Morecambe Offshore Windfarm: Generation Assets Examination Documents

The Applicant's Response to ExA's Written Questions 3

Document Reference: 9.61

7 Liverpool Bay SPA with 1.9nm CPP1 WTG and OSP Aviation Buffer and 2.4nm Calder WTG and OSP Buffer

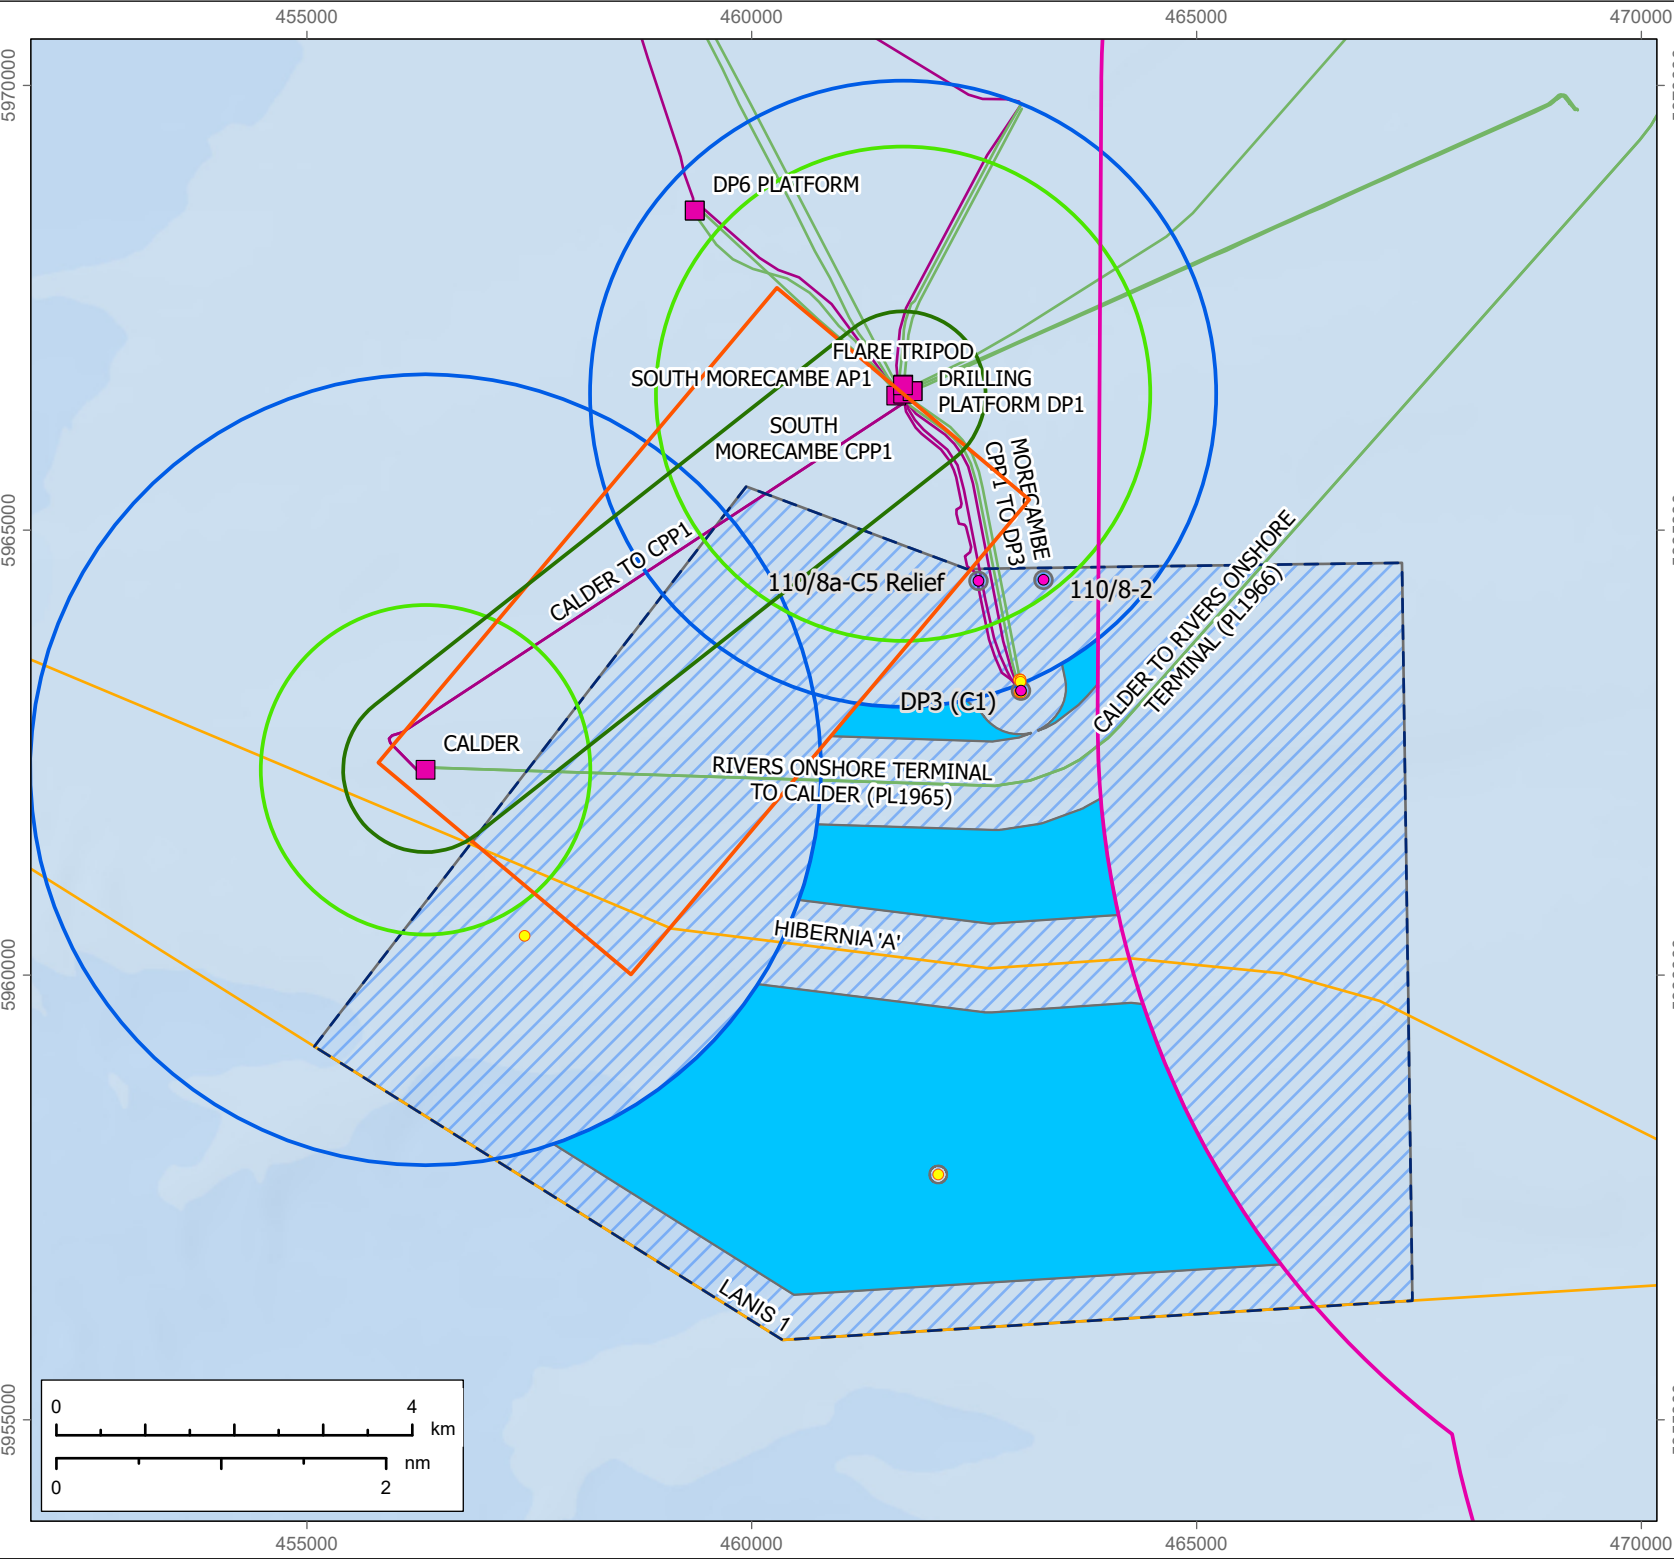
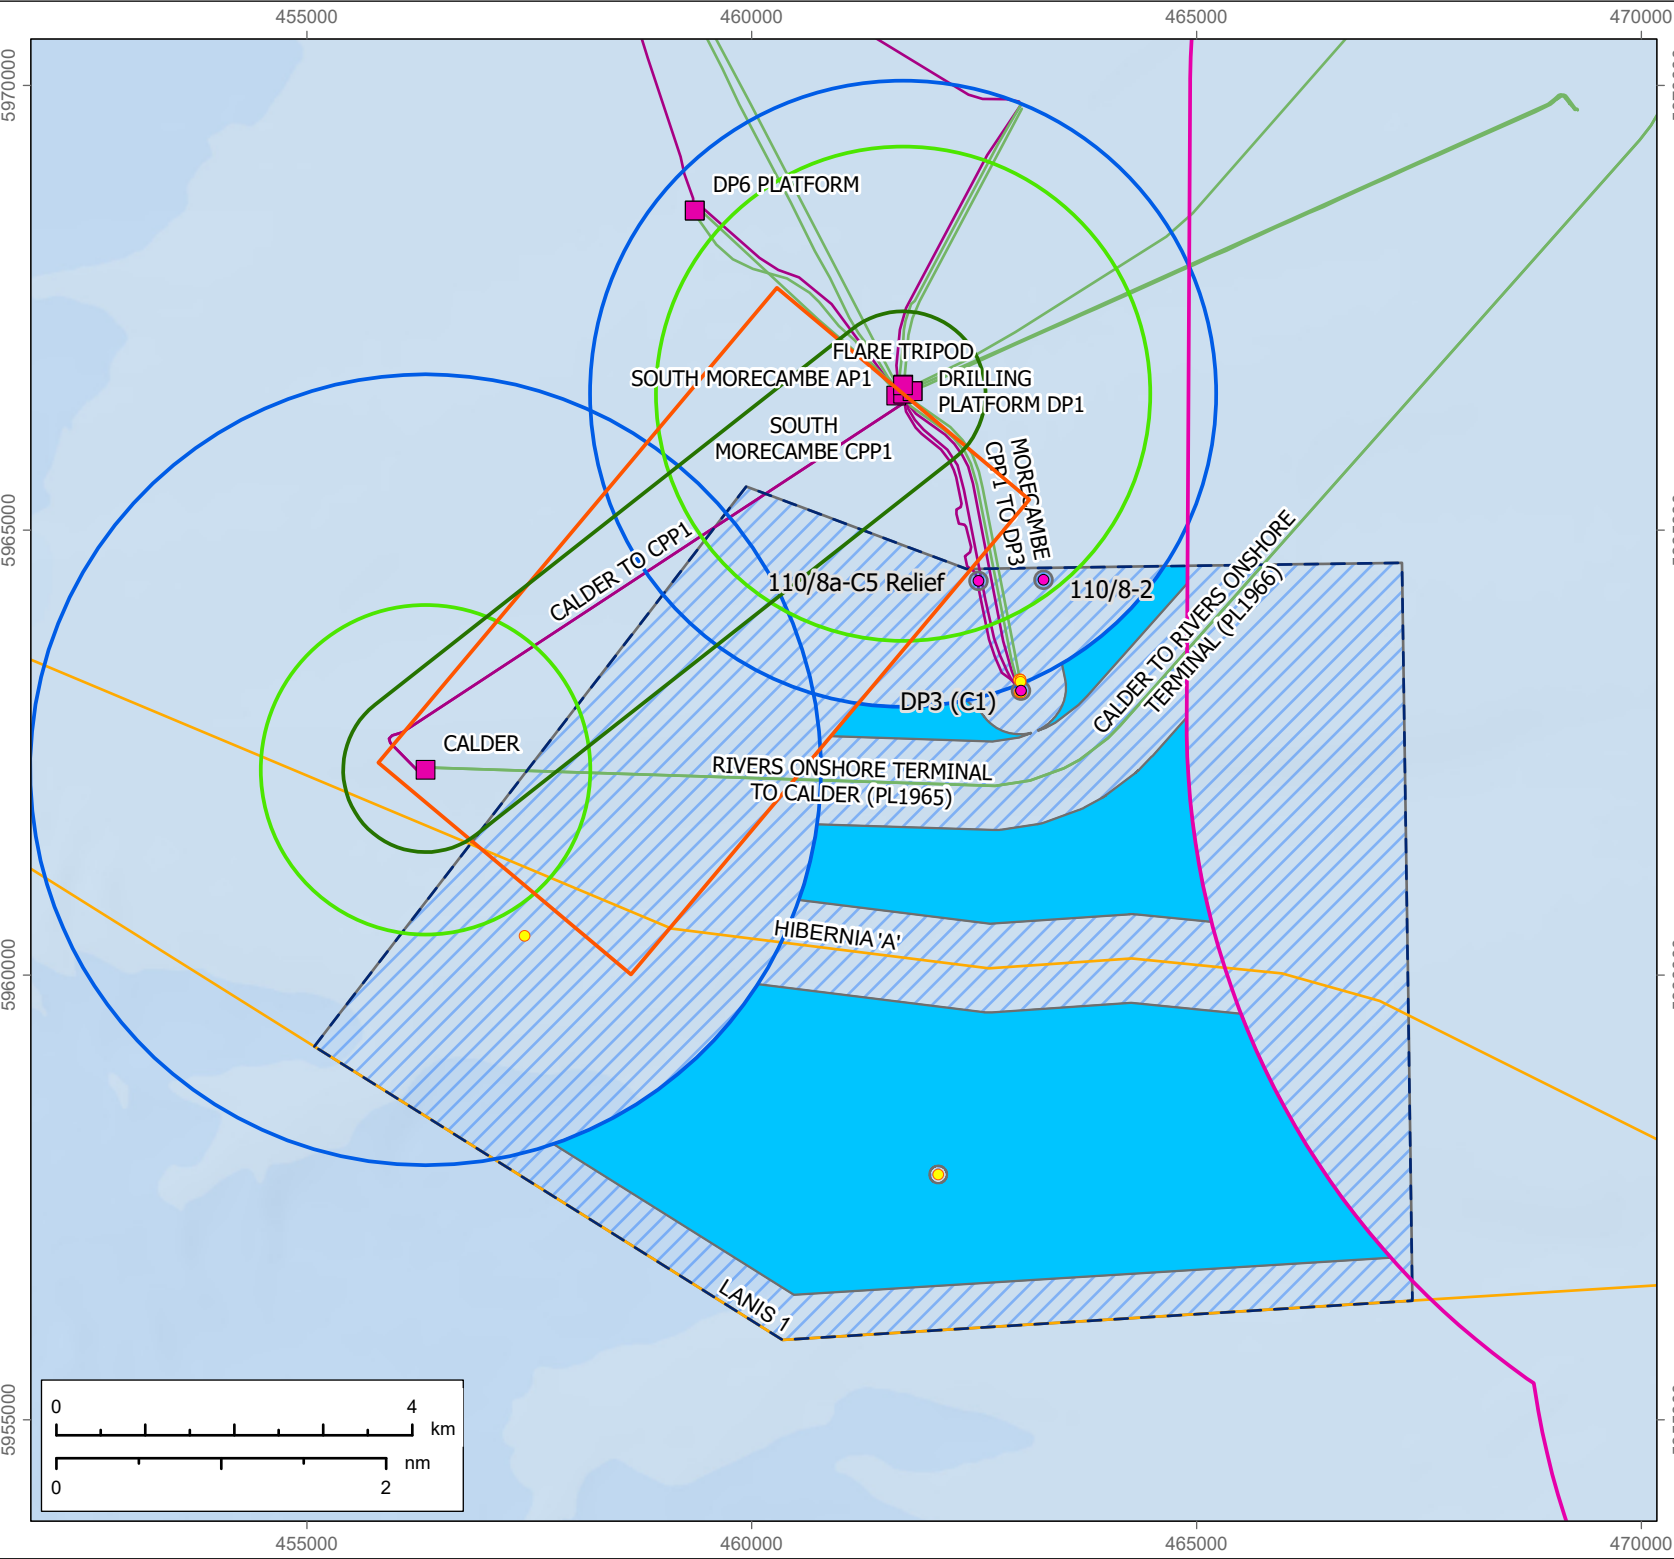
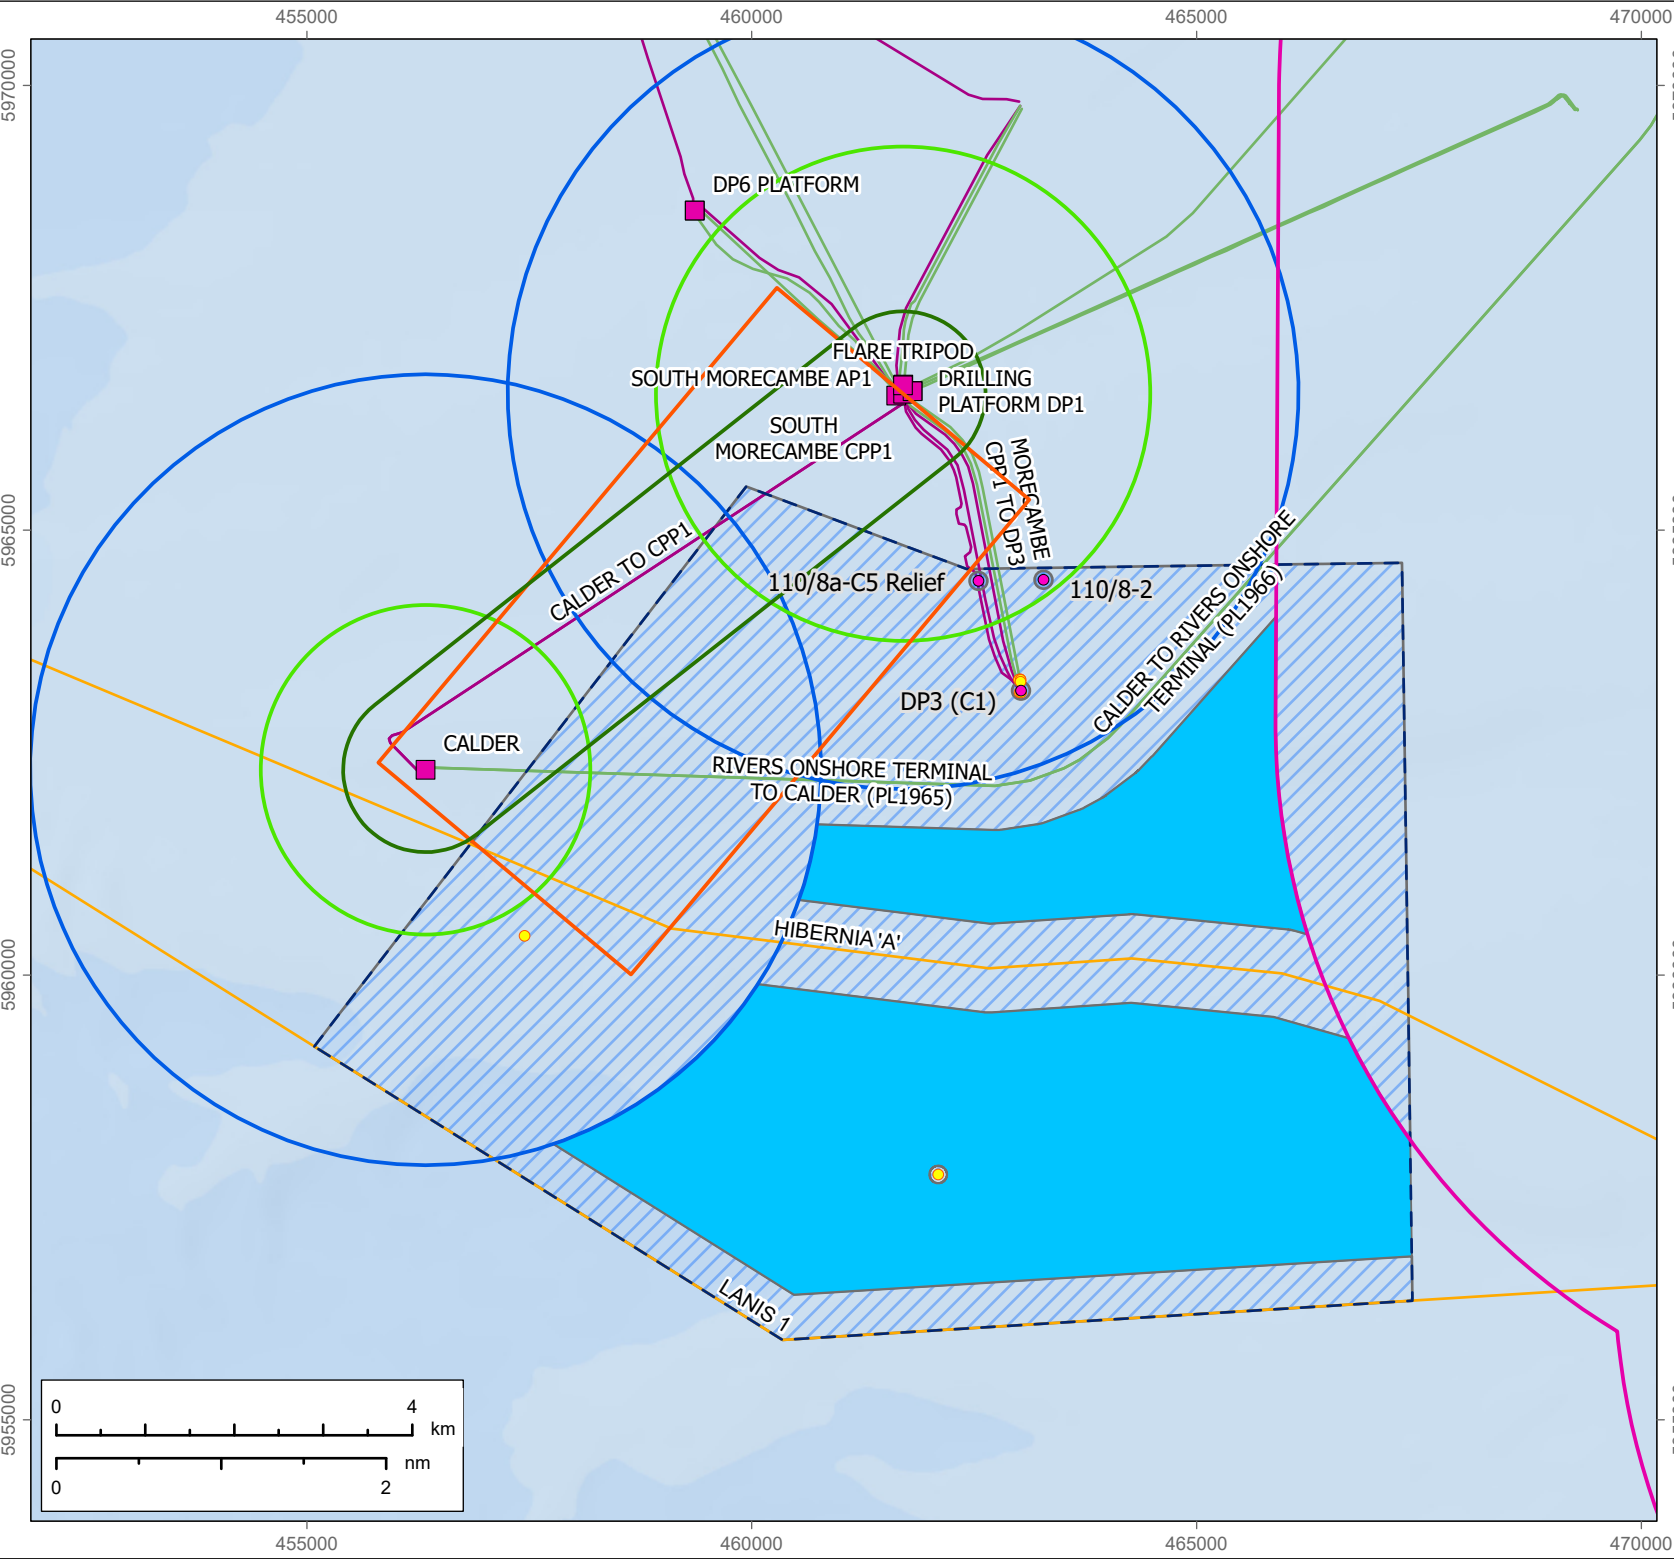
Ref.	Question to:	Question	Applicant's Response										
		<p>b) in Spirit Energy's response to ExQ2CAR5 at D5 [REP5-090] it advises a buffer distance of 1.9nm is the minimum acceptable requirement for safe landing and take-off in daytime VMC and for night VMC this distance would be 2.4nm. In light of this could the applicant provide plans for each alternative SPA buffer scenario in (a) plus each of the increased buffer scenarios from the Calder and CCP1 platforms as set out in the following table.</p>

<p>c) any additional comments or further information the applicant wishes to provide on the implications of each of the above scenarios (noting the applicant's previous response [REP5-070], EXQ2HRA3 and 2HRA6].</p> <p>The ExA is seeking a complete set of alternative scenarios shown on plans, so that, whatever the SoS may determine, if they felt it was appropriate they could include the relevant plan within any final DCO without having to revert to the applicant for that plan. Each should therefore have a different drawing number.</p>	<u>CPP1 WTG and OSP Aviation Buffer</u>	<u>Calder WTG and OSP Buffer</u>	1.9nm	1.9nm	2.4nm	1.9nm	1.9nm	2.4nm	2.4nm	2.4nm	
<u>CPP1 WTG and OSP Aviation Buffer</u>	<u>Calder WTG and OSP Buffer</u>												
1.9nm	1.9nm												
2.4nm	1.9nm												
1.9nm	2.4nm												
2.4nm	2.4nm												
3GEN4	The applicant	<p>Design Statement - Cabling</p> <p>Could the applicant please explain why (former) provision DC15 relating to use of the most direct/ efficient cabling</p>	<p>The Applicant removed the former provision DC15 as it considered that this was duplication of DC10. The Applicant has updated the Design Statement_Rev 04</p>
